Your ref: TR030001 / Able - 0016
Our ref: DC9172

The Able Marine Energy Park Development Consent Order 2012

WRITTEN SUMMARY OF THE ORAL CASE PUT BY THE MARINE MANAGEMENT ORGANISATION AT THE ISSUE SPECIFIC HEARING ON THE DEVELOPMENT CONSENT ORDER

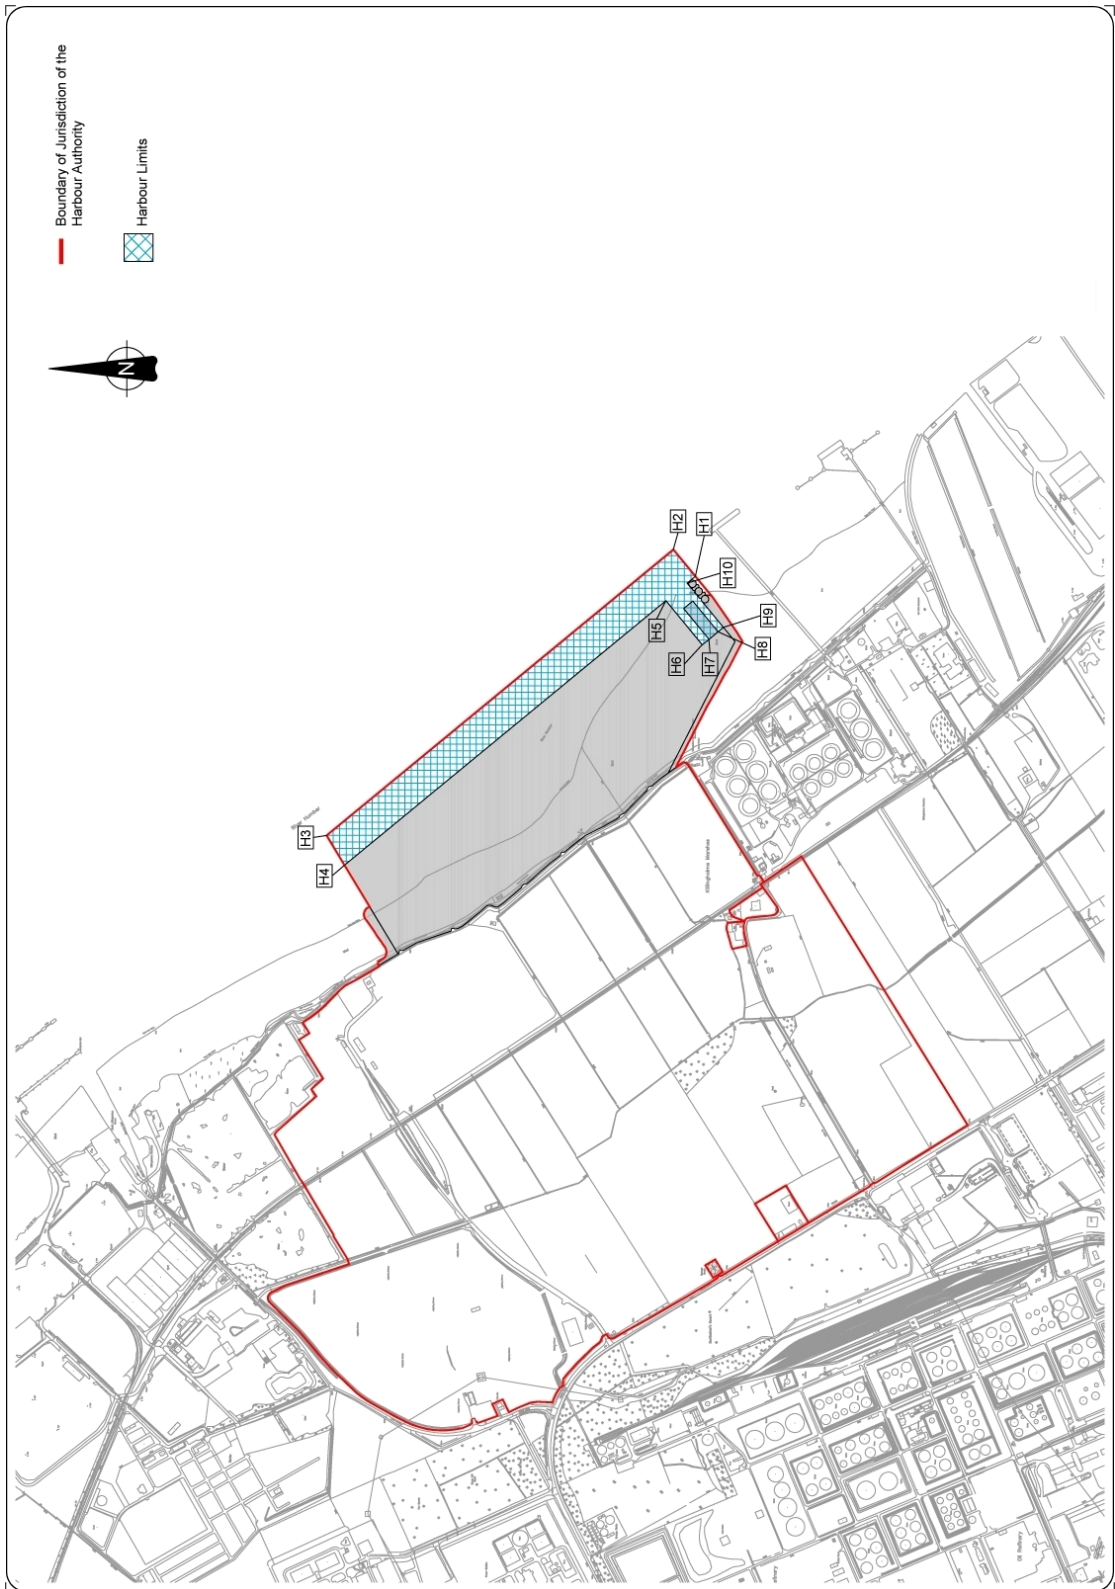
- 4.4. Schedule 10 – Limits of the Harbour: the MMO notes that the Applicant has agreed to provide coordinates to be added to the plan in Sch. 10, in line with the comments made by the MMO in its relevant representations, so that the limits of the harbour are more clearly defined.
